From: Rachel . <blparishclerk@outlook.com>
Sent: 19 July 2022 18:25
To: Planning
Subject: 3/2022/0667

Proposed Site Plan

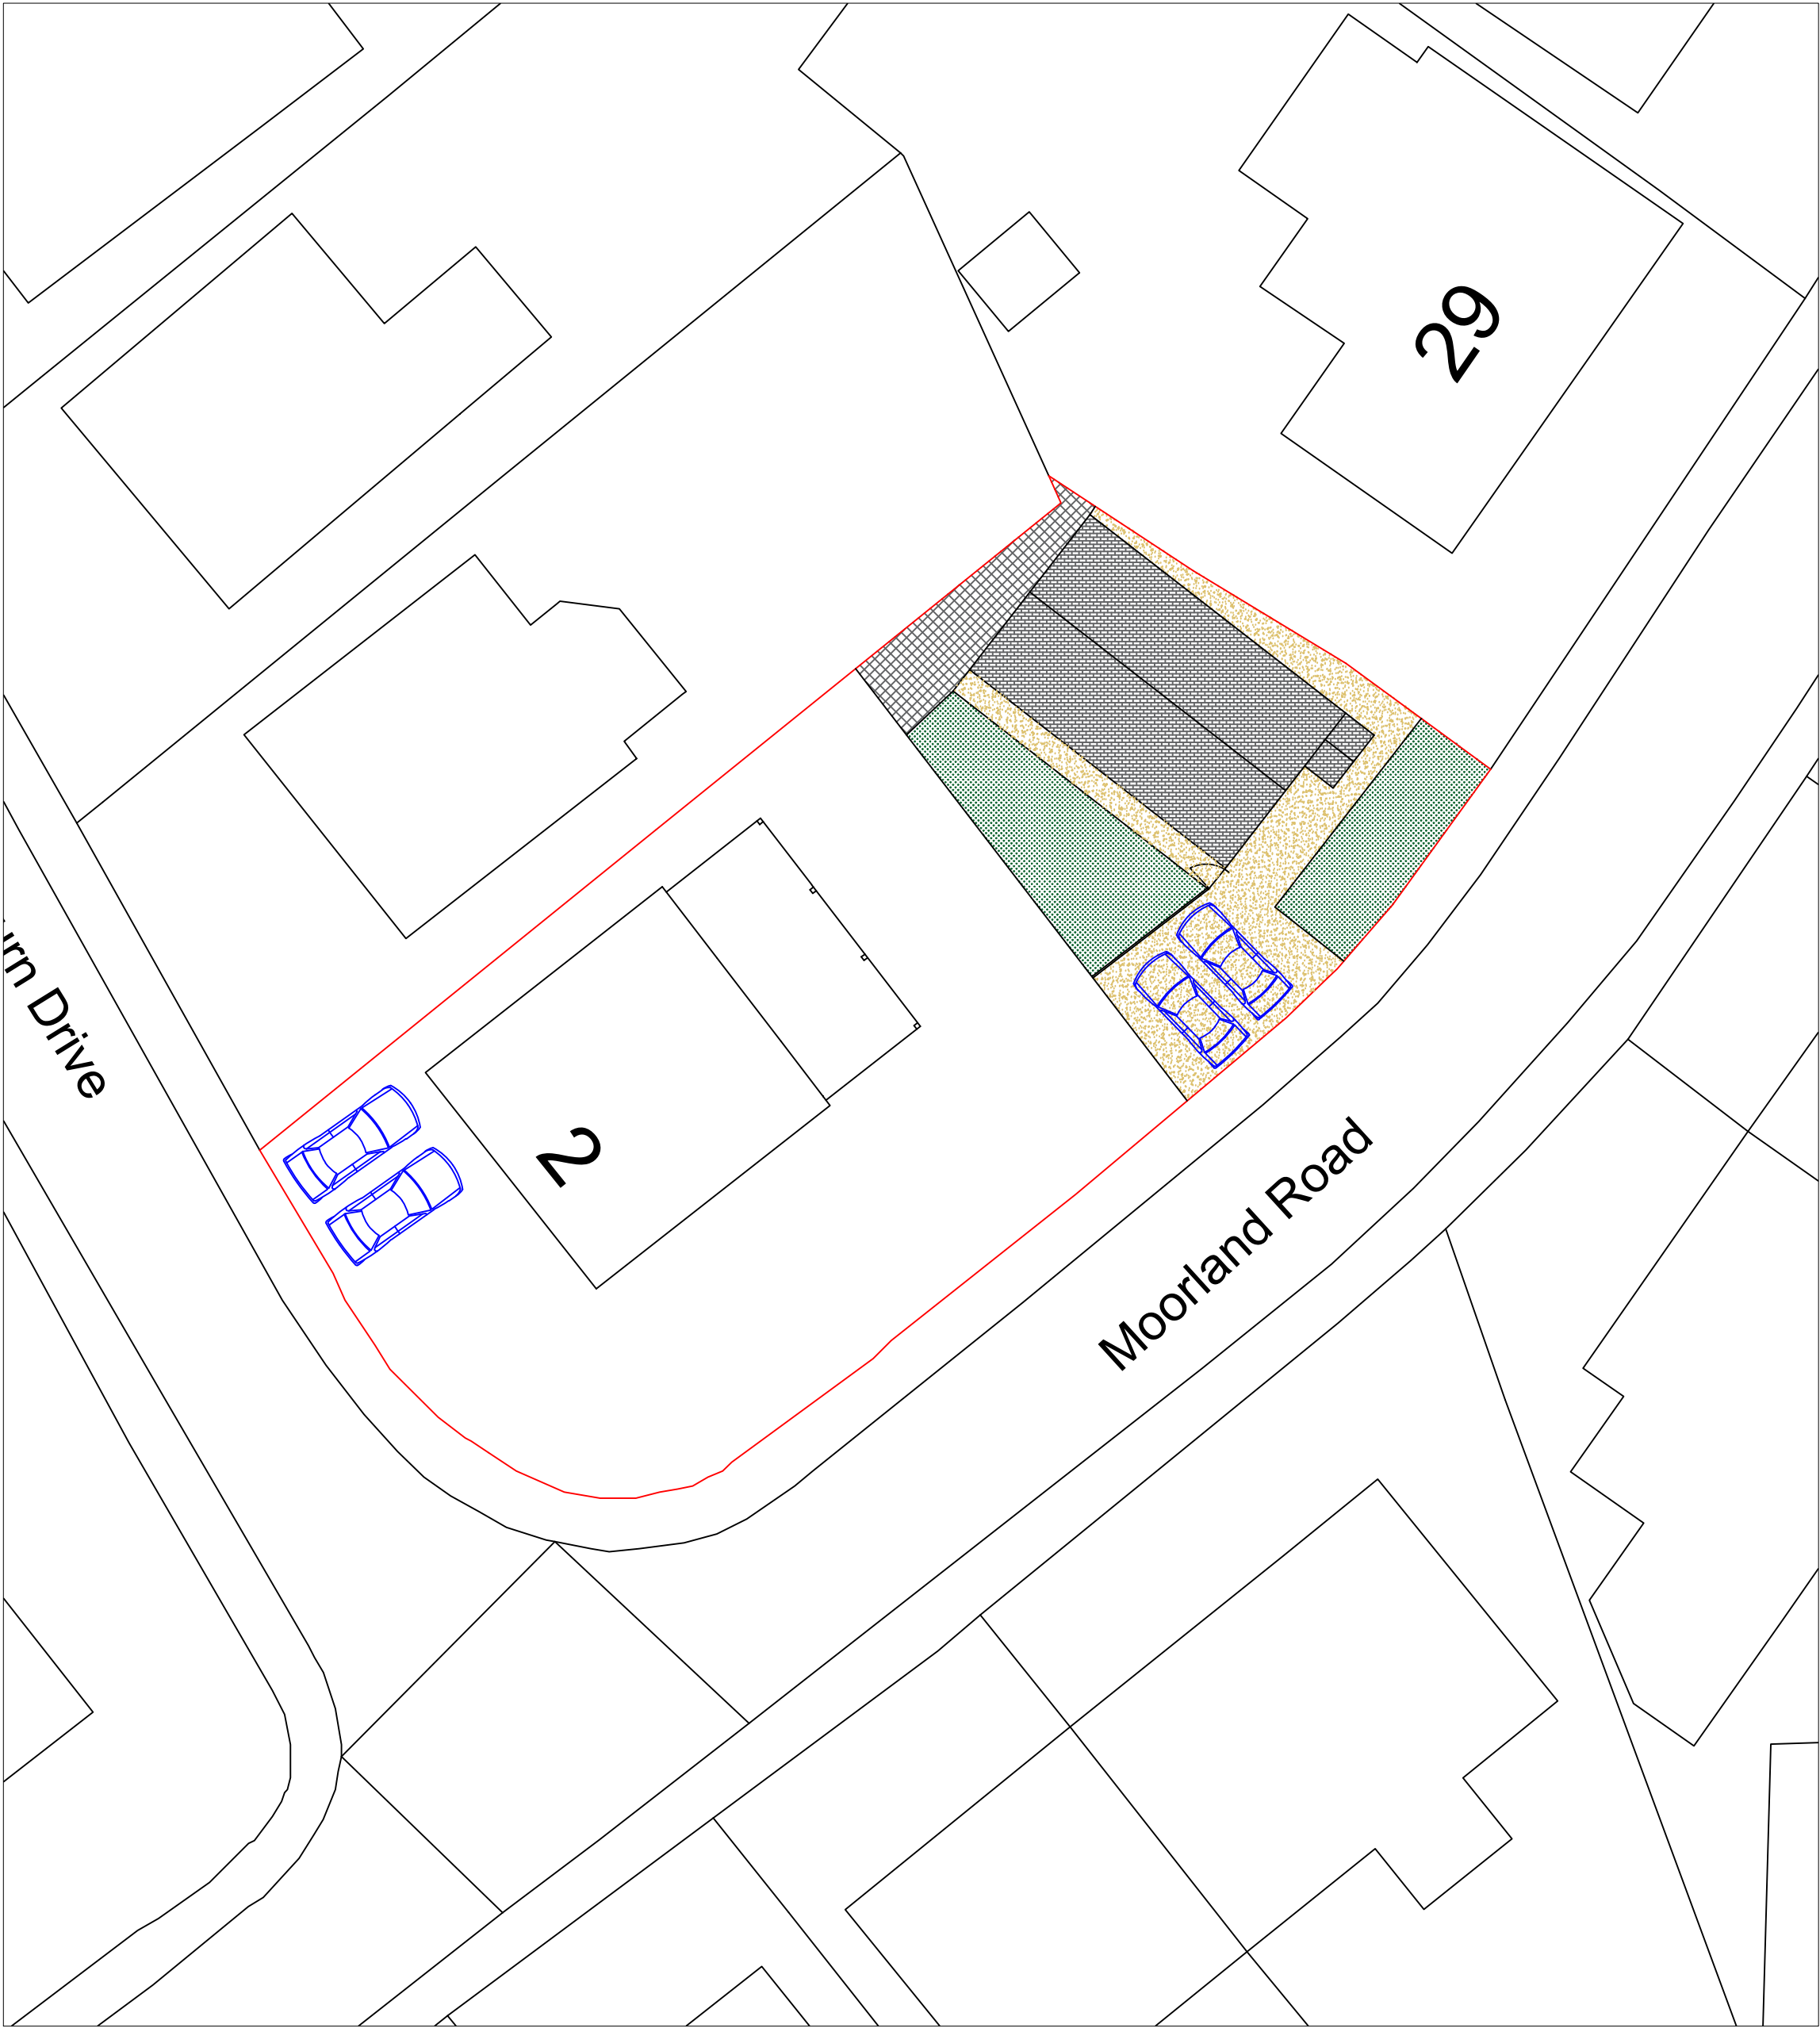
1. *This could set a precedence for with a sizeable garden within an already established settlement area is allowed to throw up new builds in their gardens*
2. *This build will stretch existing infrastructure and resources by increasing the population on the same footprint of land.*
3. *The plan view is so very tight between the existing buildings and the fence lines.*
4. *It is certainly not in keeping with the surrounding properties in design, layout or spacing.*
5. *It will impose greater than designed loads on the estate's infrastructure too Concerns were raised that the application isn't the most detailed and that the planned property drawings don't look to scale on paper unless the land to the rear of number 2 Bushburn Drive is much bigger than it appears to be.*

1. This application claims to be a resubmission of 21/1283. Despite being a second attempt, it does not seem to be an improvement, or indeed much of a change at all.
2. It is still cramped development and inappropriate for the site.
